## **REVISION RESPONSE LETTER**

**RE: Rolling Thunder Business Park  
PUD Amendment  
File Number PUD203**

**DATE:** October 13, 2020

**A1.1**  
FLOOR PLAN

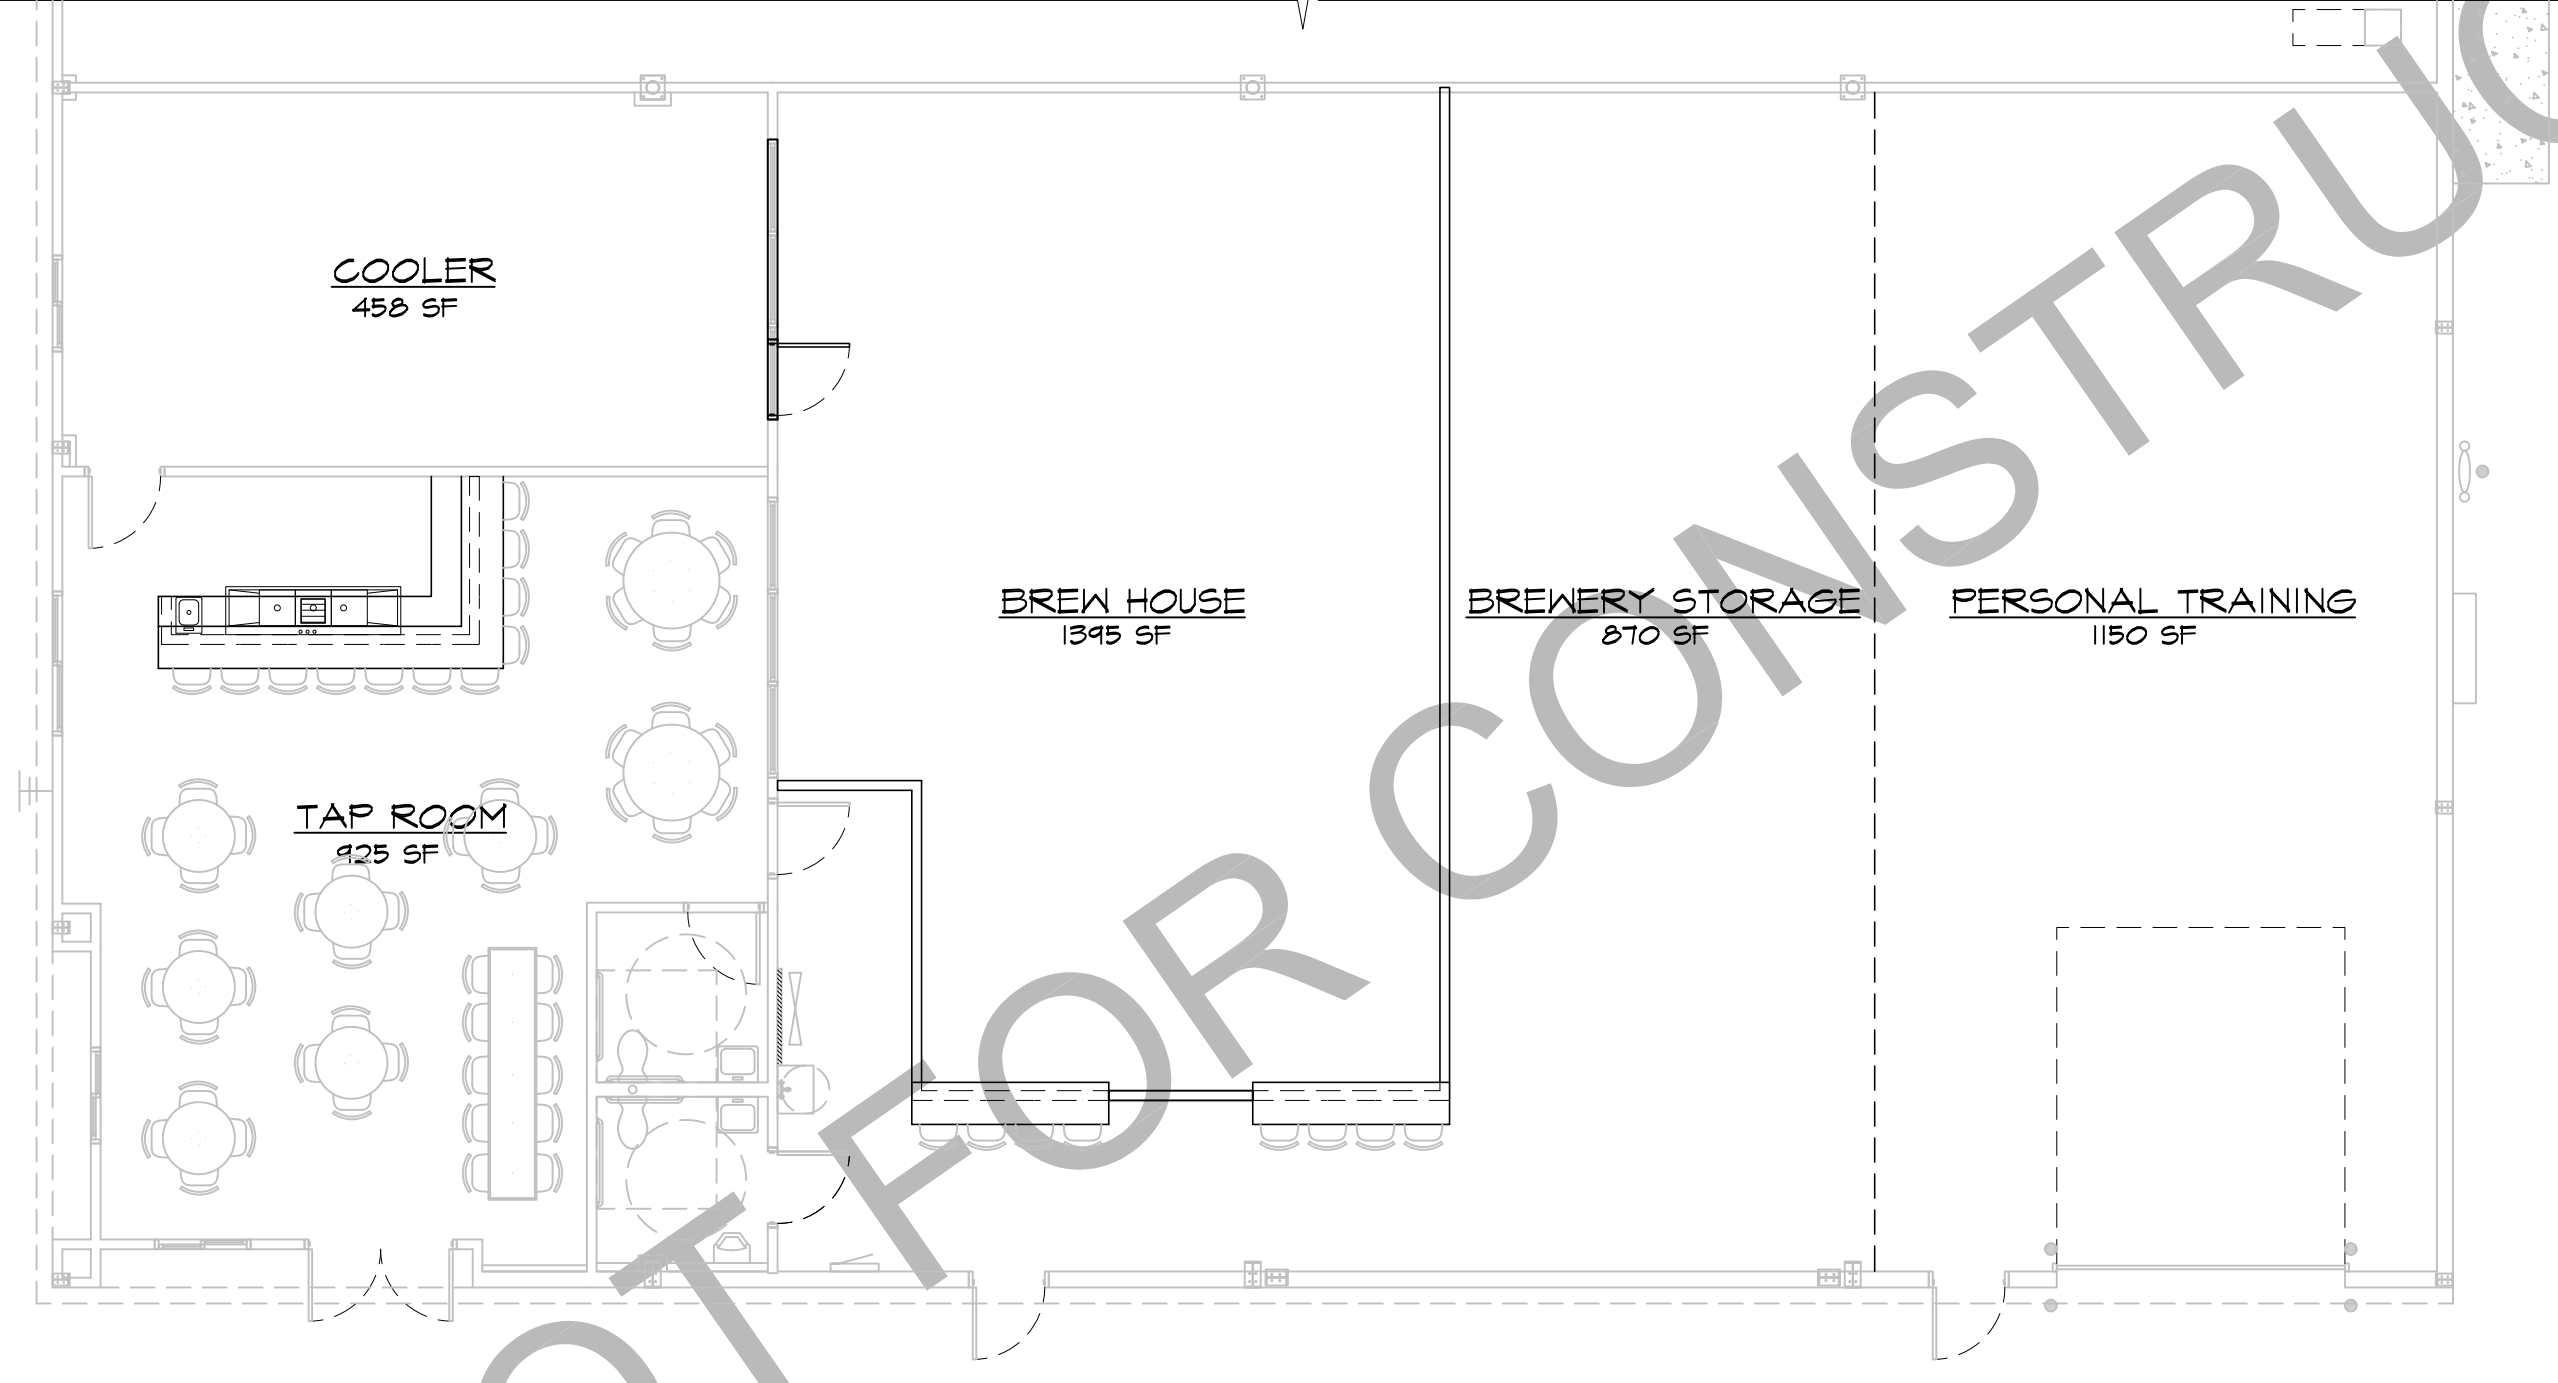
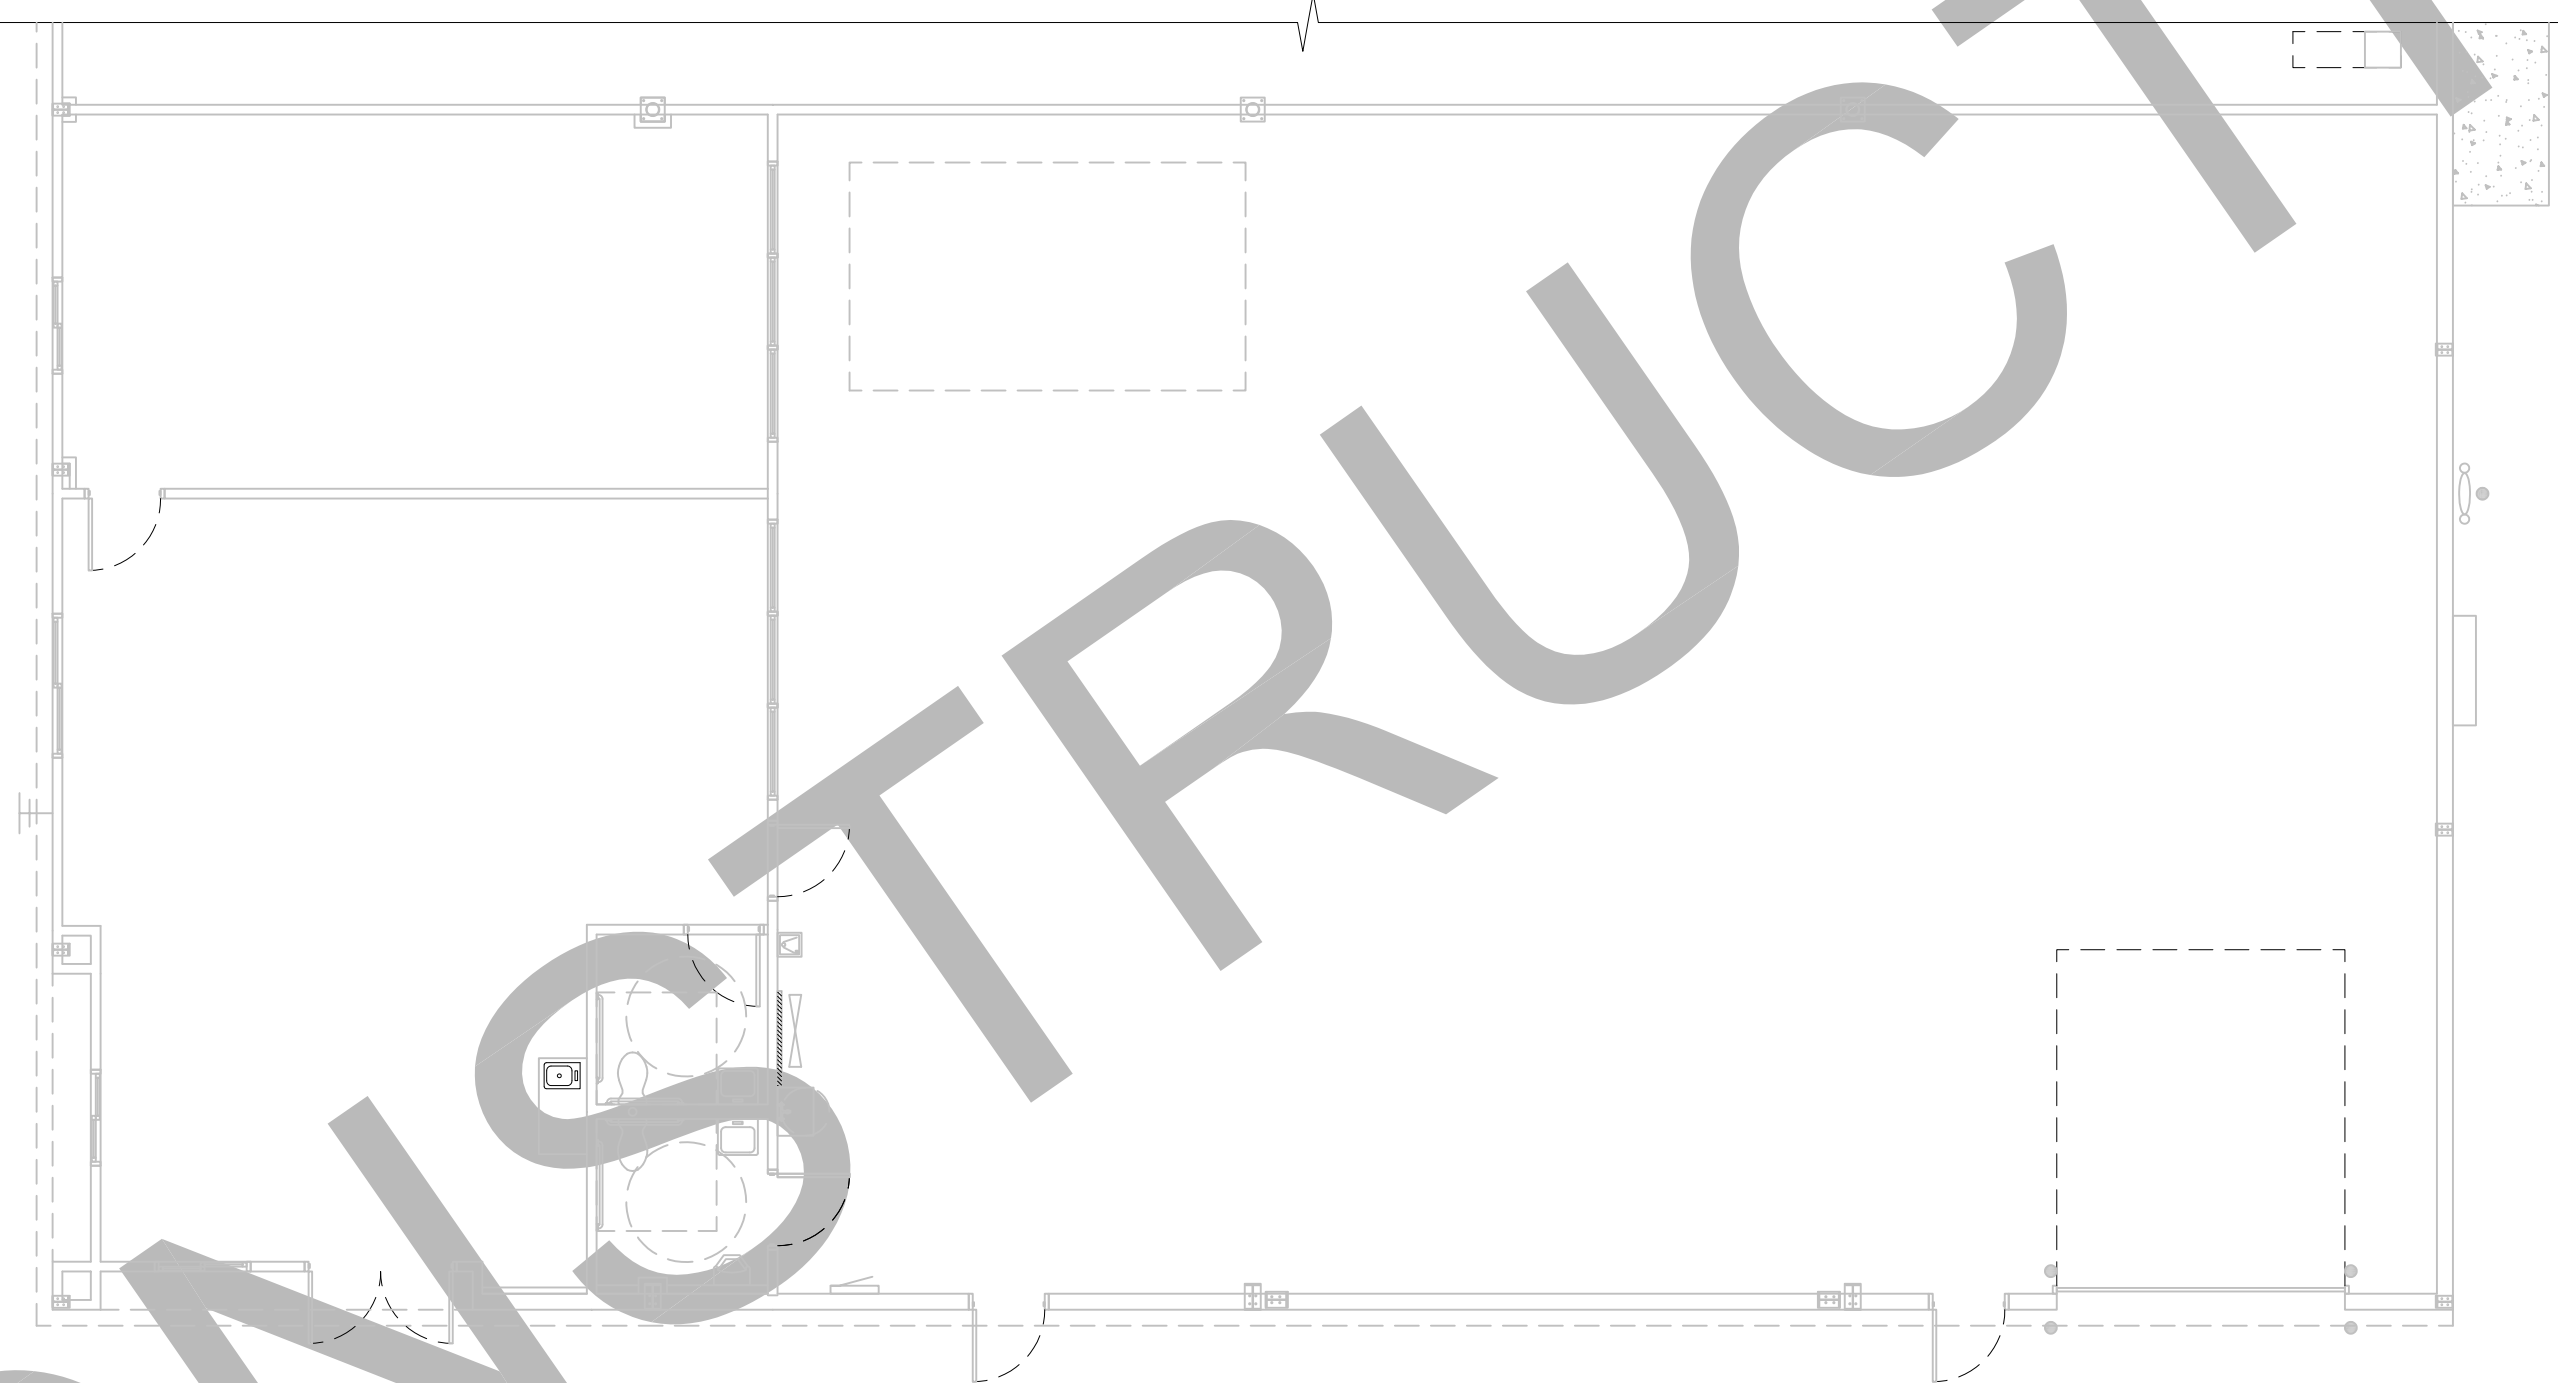
1. Is office space proposed to support the brewery or taproom of gym uses? If so, please show on the floorplan. **No. This space is not the main operations headquarters for the owner's businesses, and as such, all important documents and files will be held offsite**

2 FLOOR PLAN
SCALE: 1/8"=1'-0"

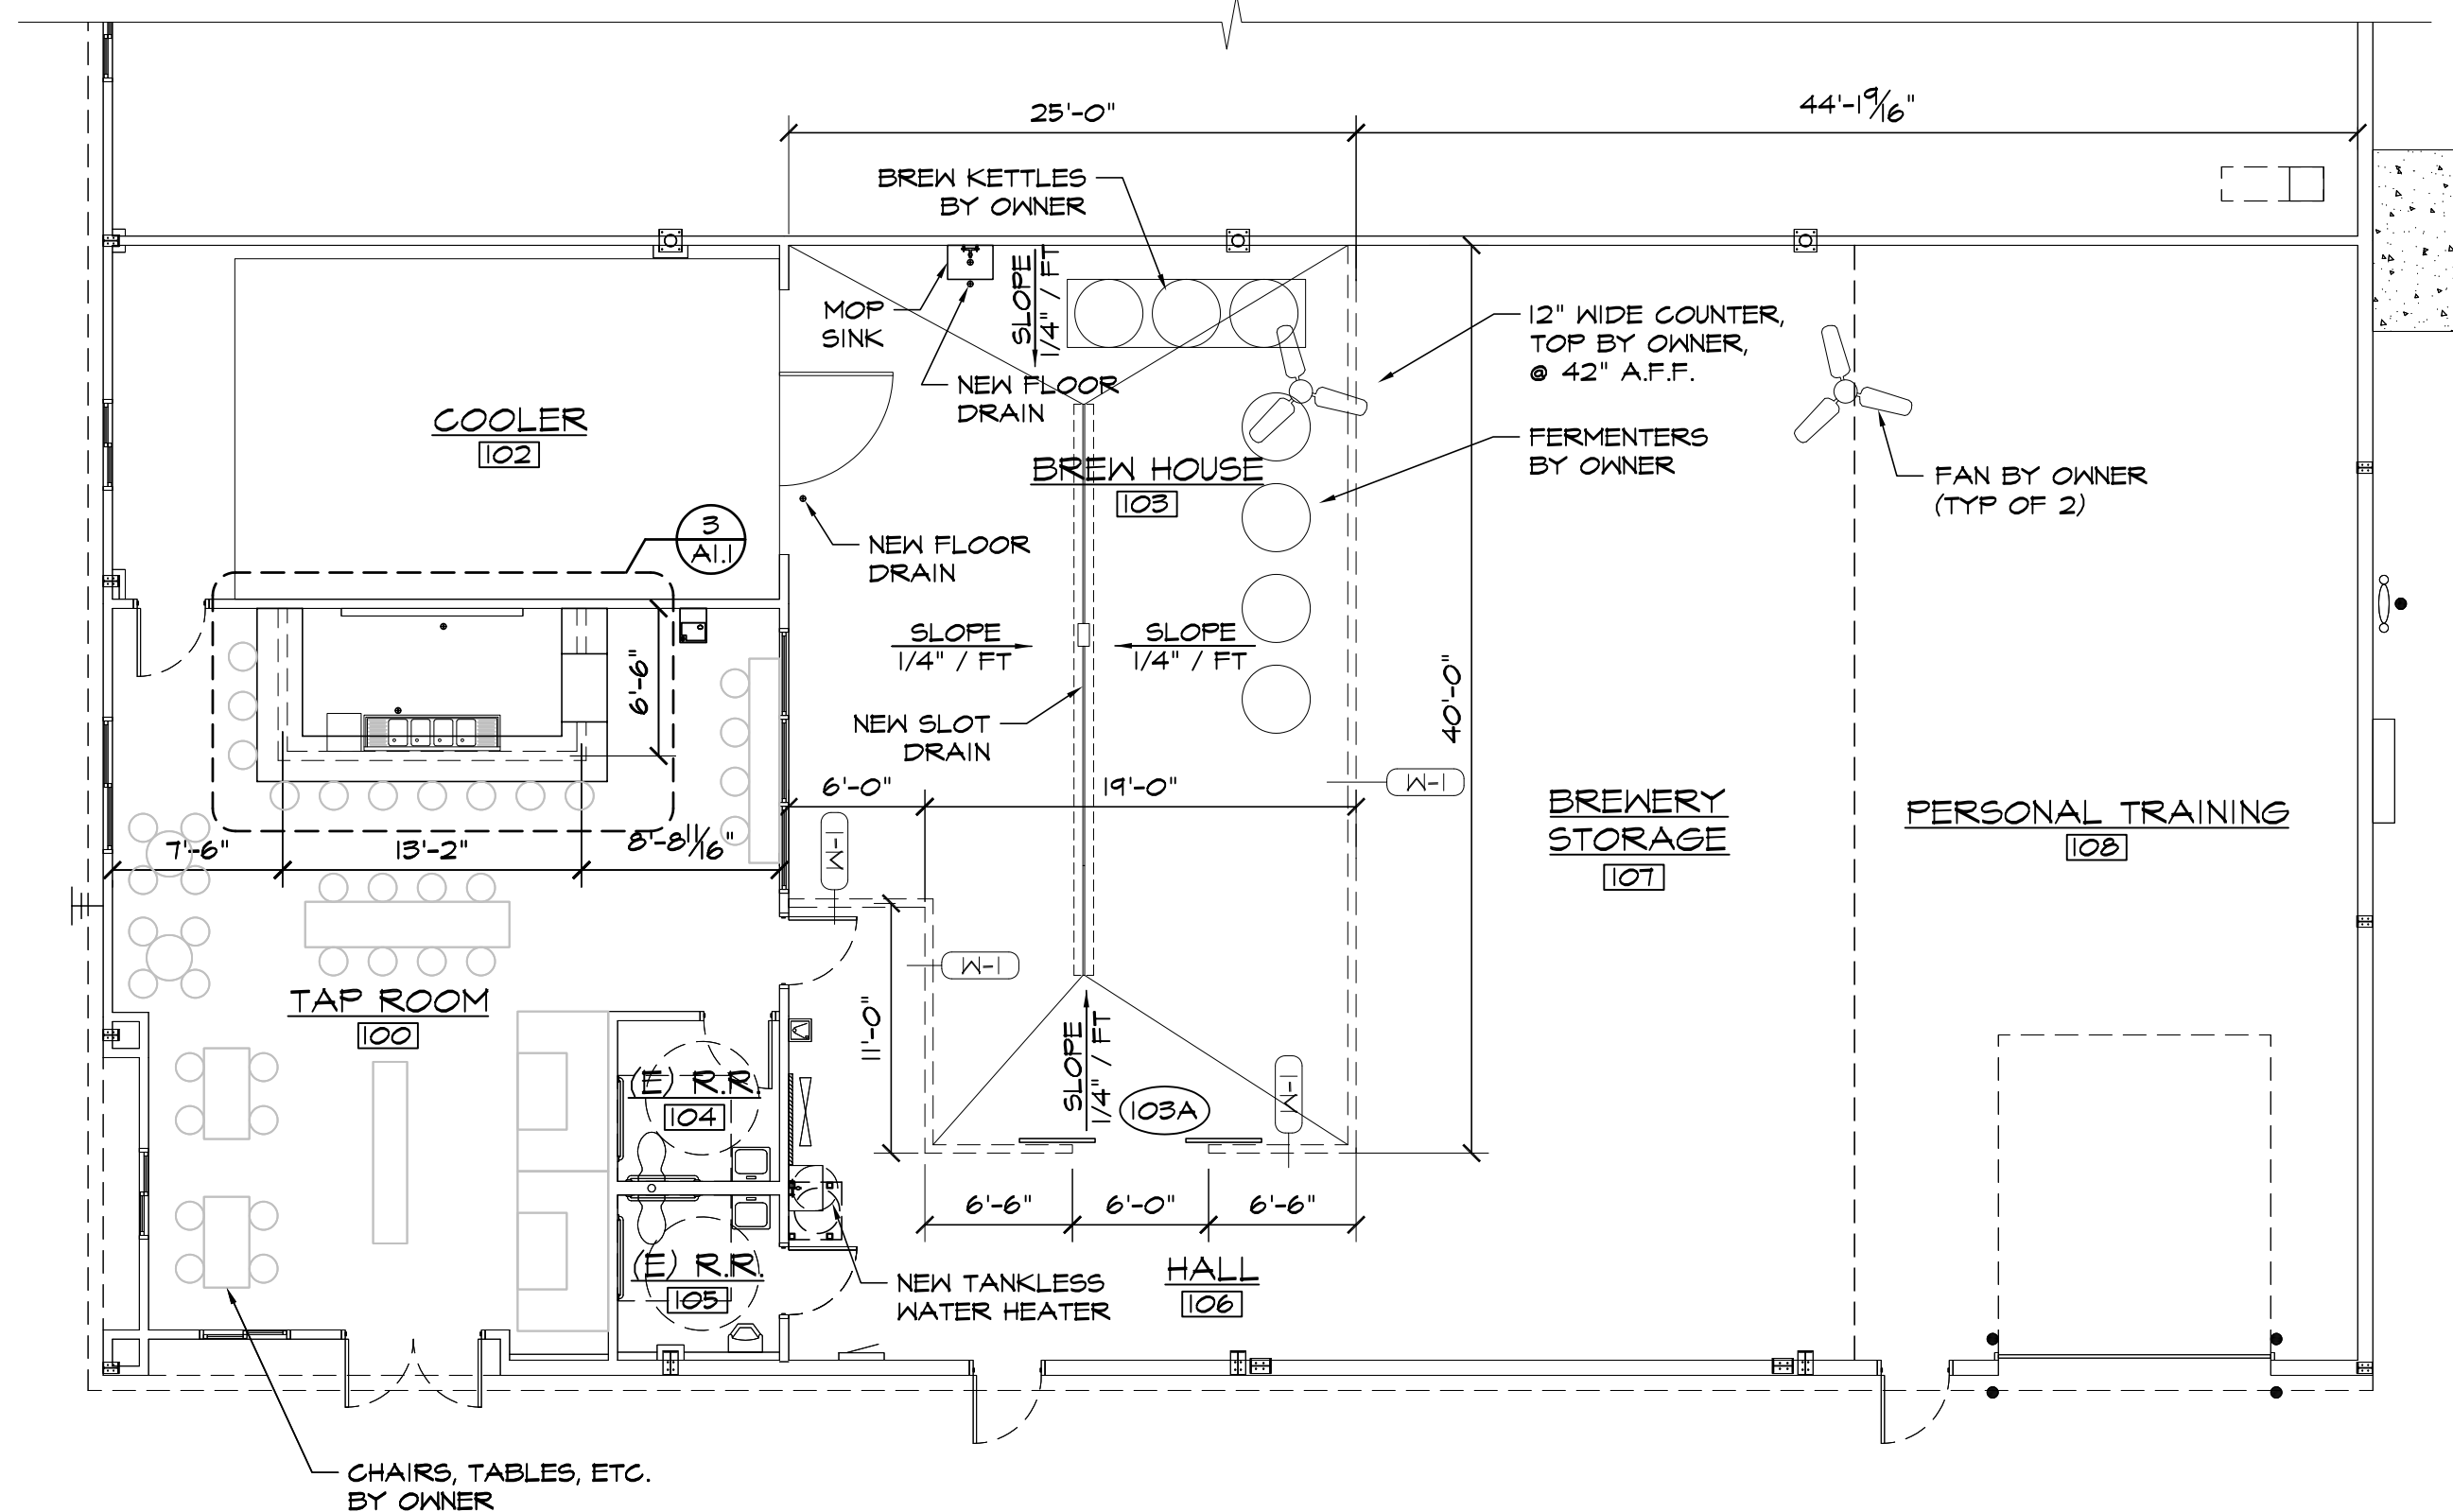
1. Regarding a request for approval of an amendment to a PUD development plan, Enumerations has the following comments: 1. It appears that the space labeled on the plan as personal training will be a separate tenant space with no connection to the brewery space. If that is the case, Then each tenant space will need to be assigned a suite number. Brent Johnson Enumerations Plans Examiner Pikes Peak Regional Building Department O: 719-327-2888 E: [brent@pprbd.org](mailto:brent@pprbd.org) W: [pprbd.org](http://pprbd.org) **This is not a separate tenant space. The dashed line on the plans is to indicate separation of uses within the building for calculation of occupancy, parking, etc. There are no interior walls in that area.**
